3W
United Utilities Water PLC
Developer Services & Planning
Thirlmere House
Lingley Mere Business Park
Lingley Green Avenue
Great Sankey
Warrington WA5 3LP

Your ref: 3/2012/0845
Our ref: DC/12/4171
Date: 06-NOV-12

Location: Land off Chapel Close Low Moor Clitheroe Lancashire BB7 2ND
Proposal: Discharge of condition 5 surface water drainage scheme

Adoptable Drainage  
Layout

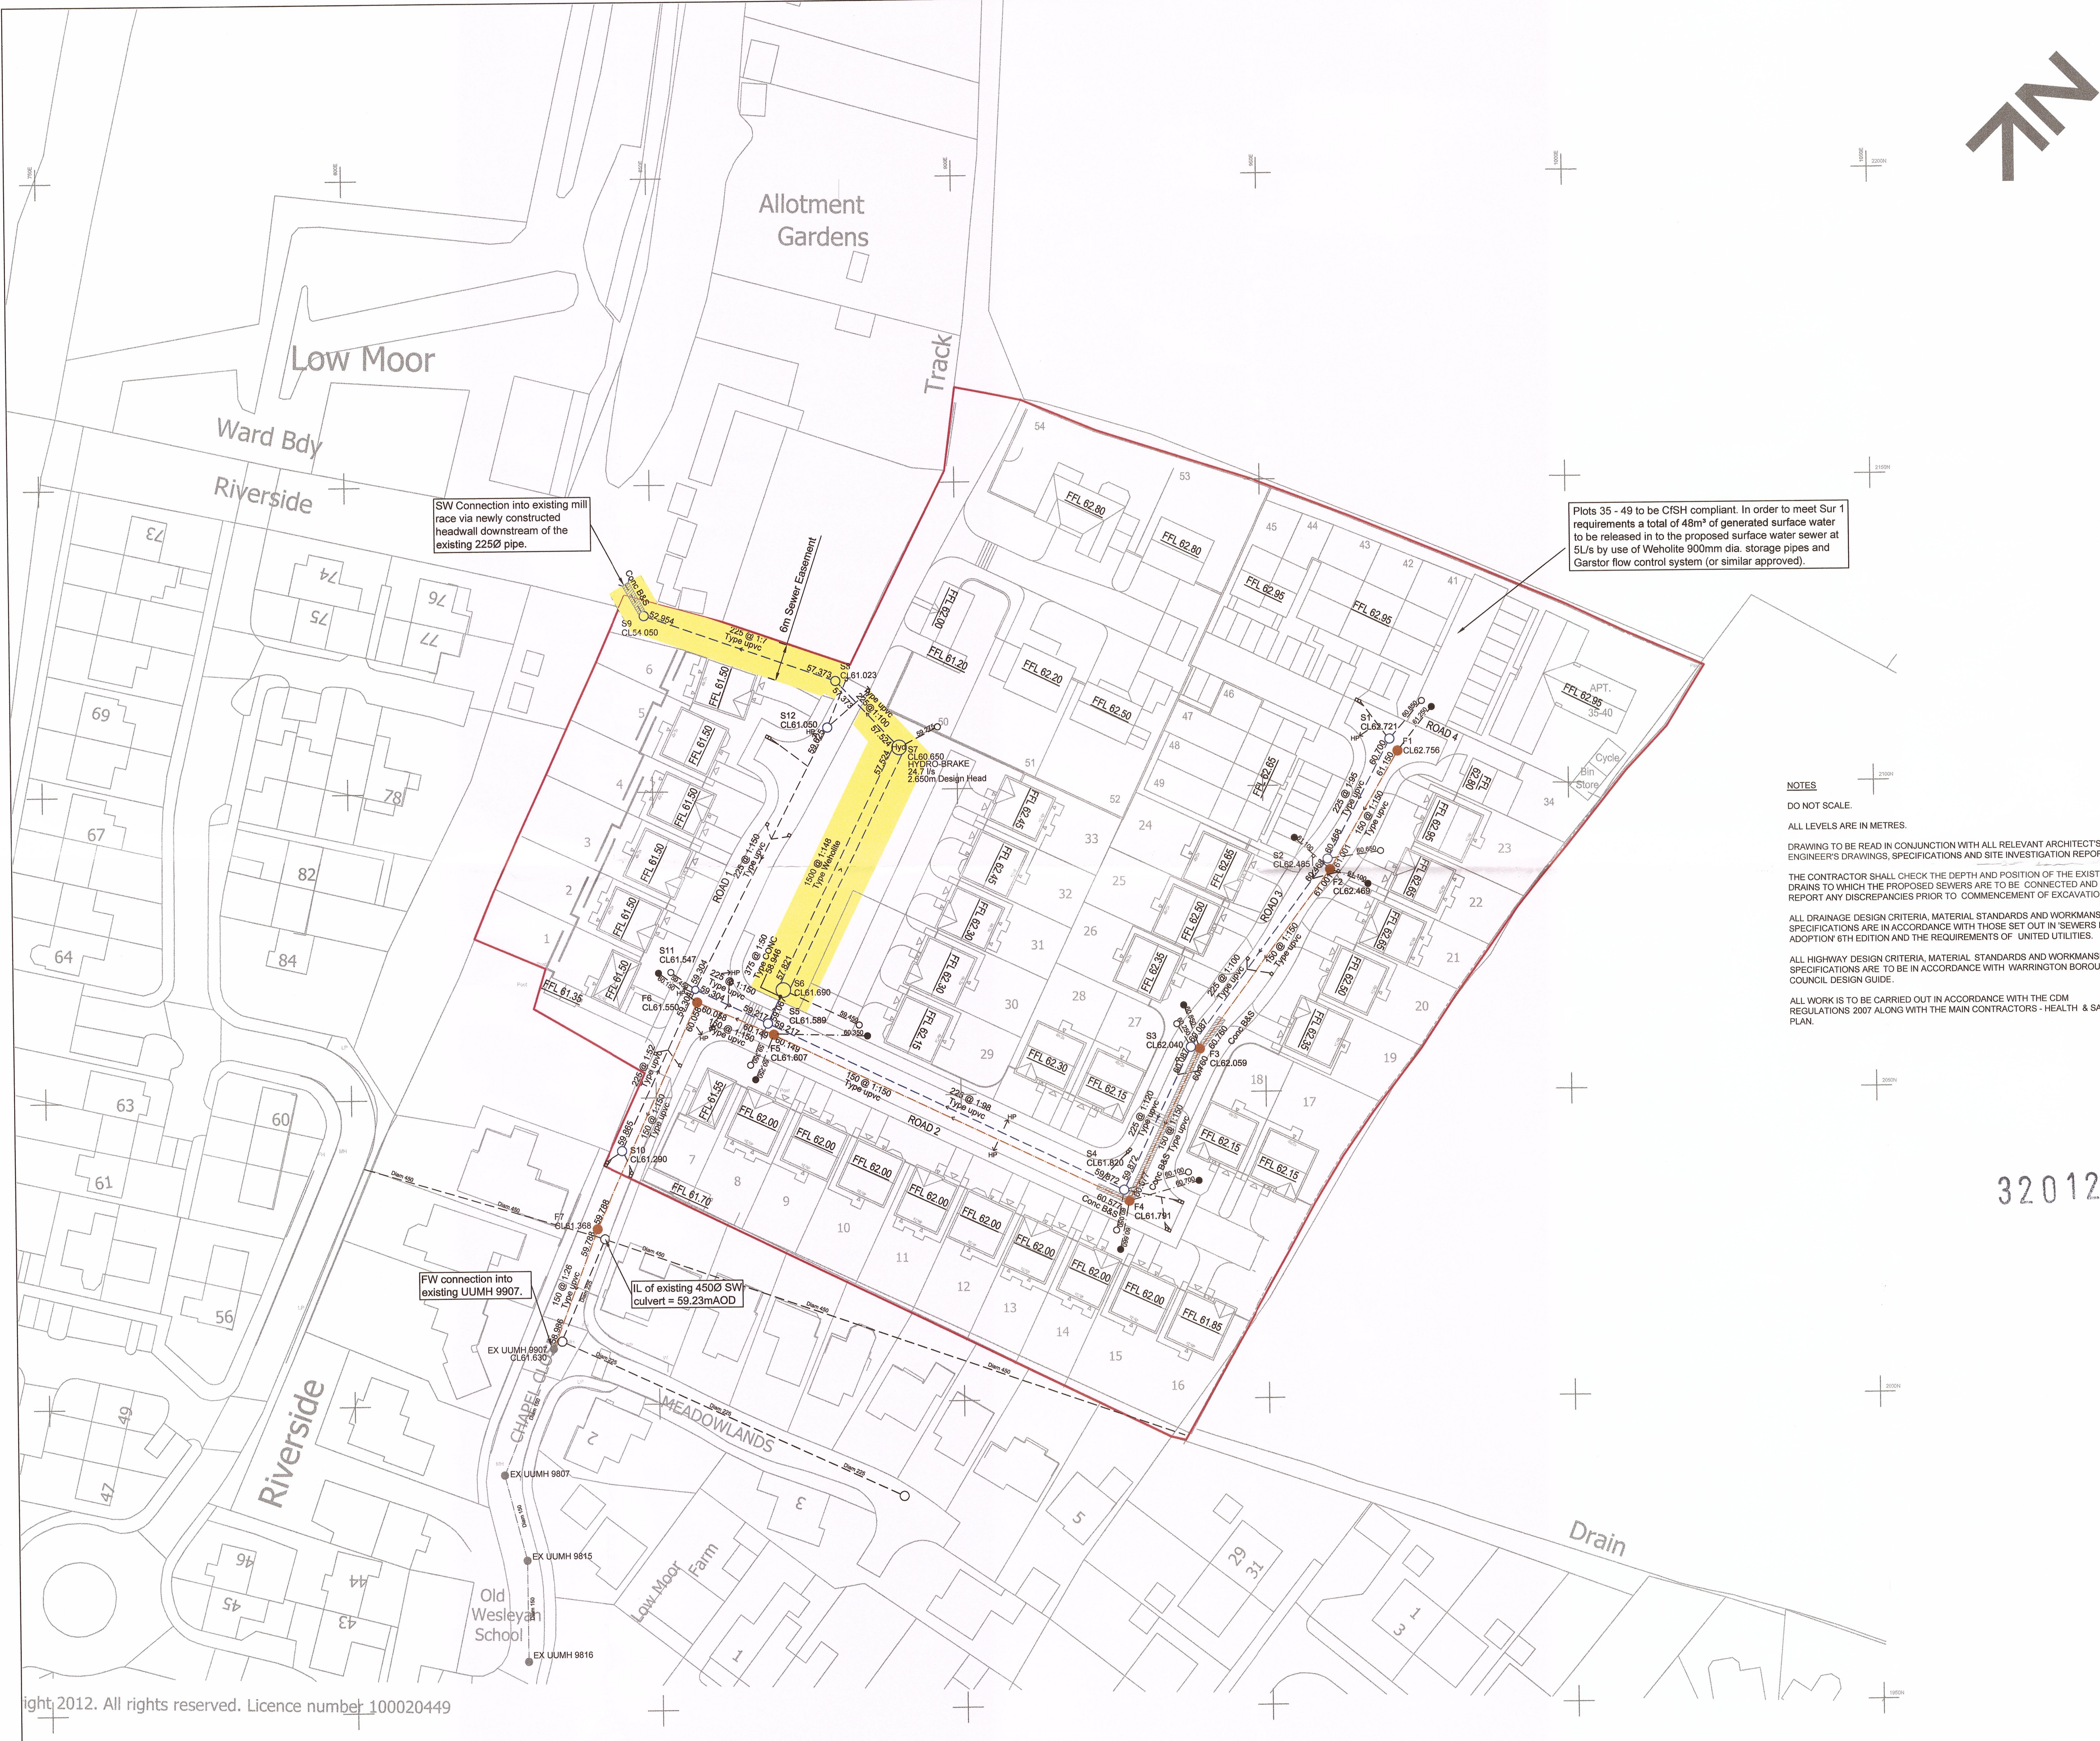
I can confirm that conditions 5 & 6 of planning approval 3/2011/0247 can be discharged providing that the drainage scheme is built in line with the principles outlined on drawing no 40-01 Rev P5.
